Our Case Number: ACP-324350-26

Re: Proposed development of 360 no. residential units

Mooretown, Swords, Co. Dublin

Subject of Appeal - Request for Increased Height of Boundary Wall for Security and Privacy.

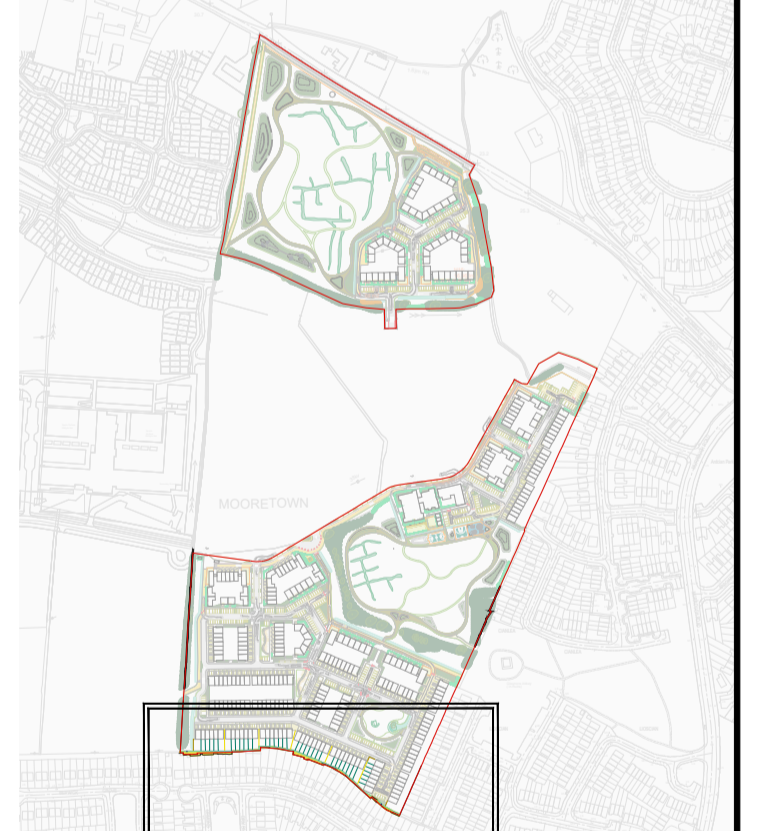
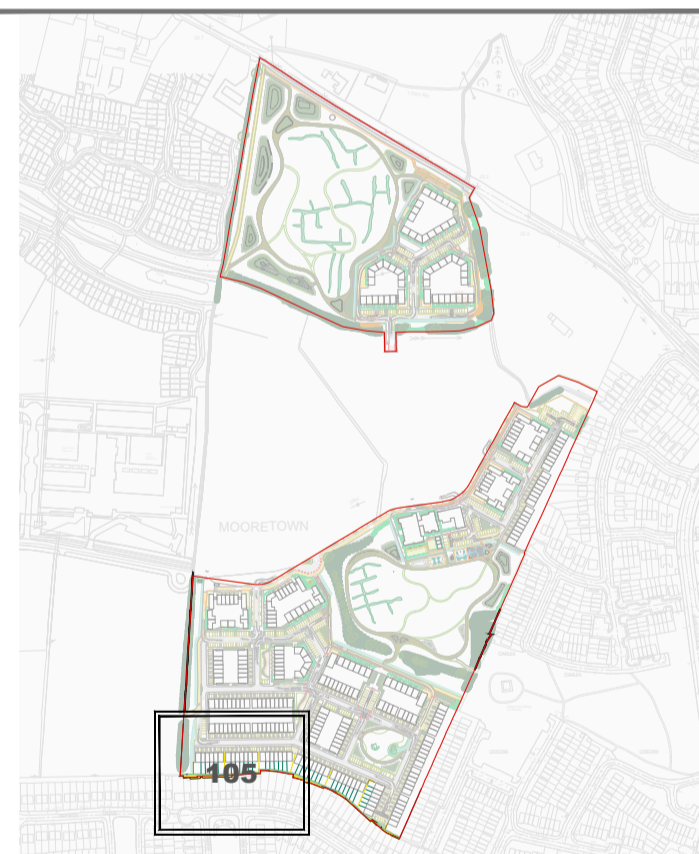
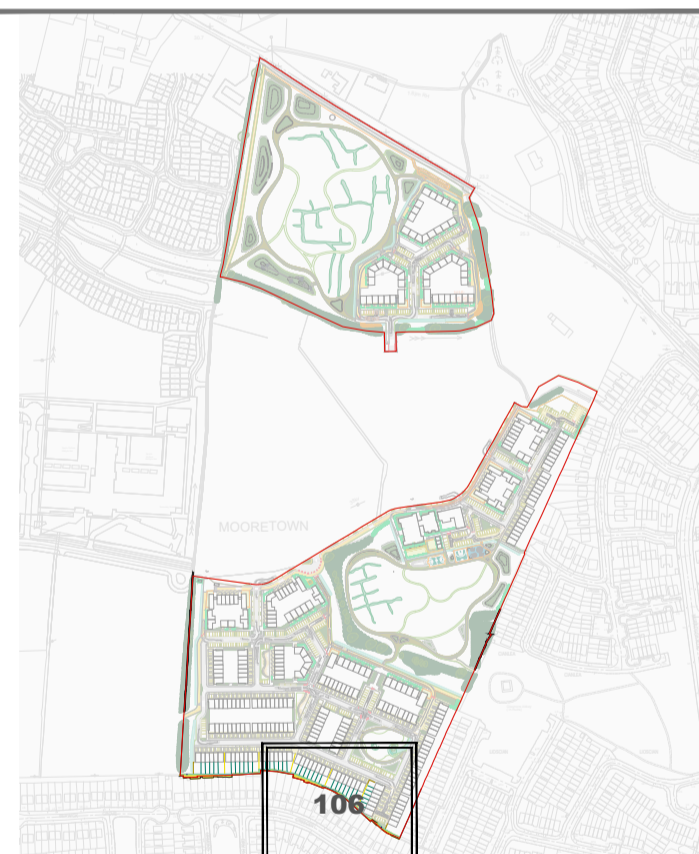
However, I am requesting that the existing boundary wall be increased in height, as I do not believe it is sufficient to protect the privacy and security of my home once the development is completed.

The proximity of the proposed public open space and parking spaces is likely to increase pedestrian activity immediately behind my garden, resulting in a greater risk of overlooking, noise, anti-social behaviour, and reduced enjoyment of my property.

I am also concerned that, due to my property having a large side entrance and being located on the main junction of Cianlea, it could become an informal rat run if a more secure boundary is not provided. This may lead to people trespassing, particularly given the longer walking distance along the public footpath on Rathbeale Road after using public transport.

In addition, I would ask that some form of sound barrier be considered between the boundary wall and the proposed green area and car parking spaces, particularly due to people working shifts and coming and going at unsociable hours. I am also concerned that the wide-open space between my property and the neighbouring property may act as a sound tunnel, funnelling noise unless appropriate measures are put in place.
